Your ref:	49 South Audley Street - Shop...	Please reply to:	Central Planning Team
Our ref:	24/01654/FULL	Tel No:	2514
		Fee Queries:	0207 641 6500;
		Email:	planningreception@westminster.gov.uk;
Mrs Danielle Zaire Monmouth Planning Ltd 38A Monmouth Street LONDON WC2H 9EP		Incomplete Applications Town Planning & Building Control City of Westminster PO Box 732 Redhill, RH1 9FL	
		25 March 2024

Address: Basement And Ground Floor, 49 South Audley Street, London, W1K 2QD,

Proposal: Alterations to the shopfront including the addition of timber moldings to the existing glazing and a replacement door on the South Audley Street side; installation of a new metal framed shopfront and timber moldings to the glazing on the Reeves Mews frontage; installation of 2 downlighters to the South Audley frontage and 7 downlighters to the Reeves Mews frontage; and refurbishment of the existing stone frame. (Linked with 24/01655/ADV)

PROPOSED PLAN
SCALE 1:100

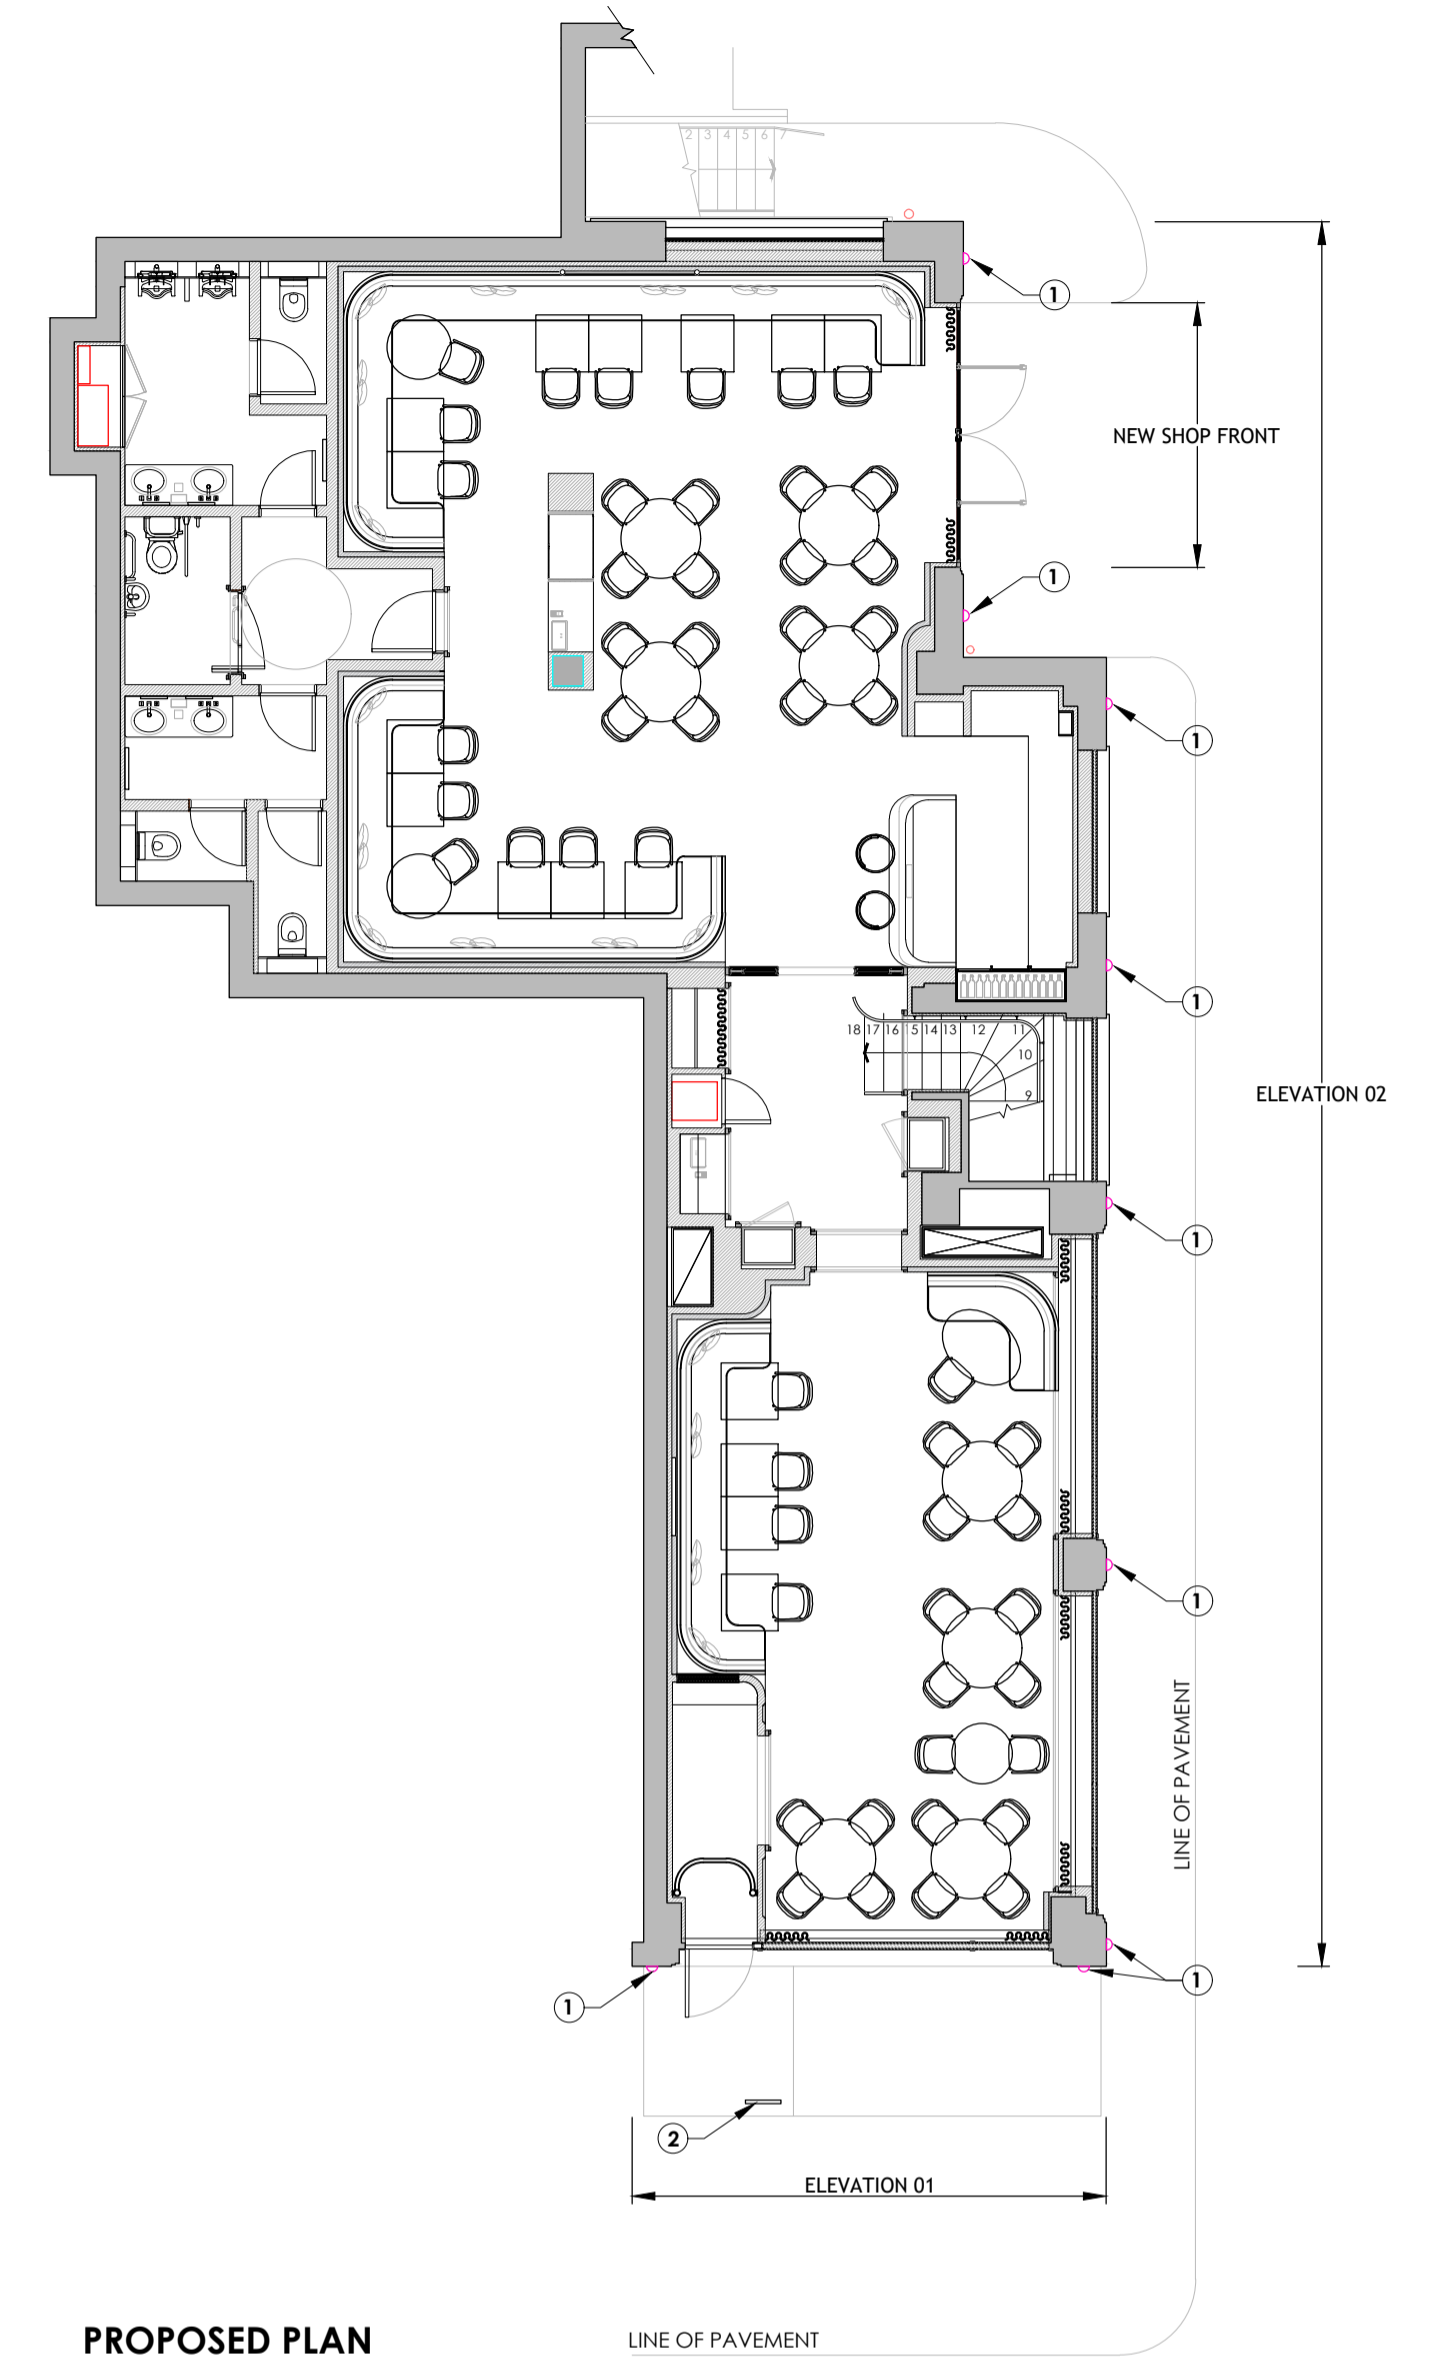
Existing floorplan to correspond with the proposed floorplan submitted.

Your proposal would appear to incorporate the off-street loading bay into the demise of the retail unit. You are advised to provide some analysis of the use of this loading bay and the implications for traffic movements and parking resulting from its loss.
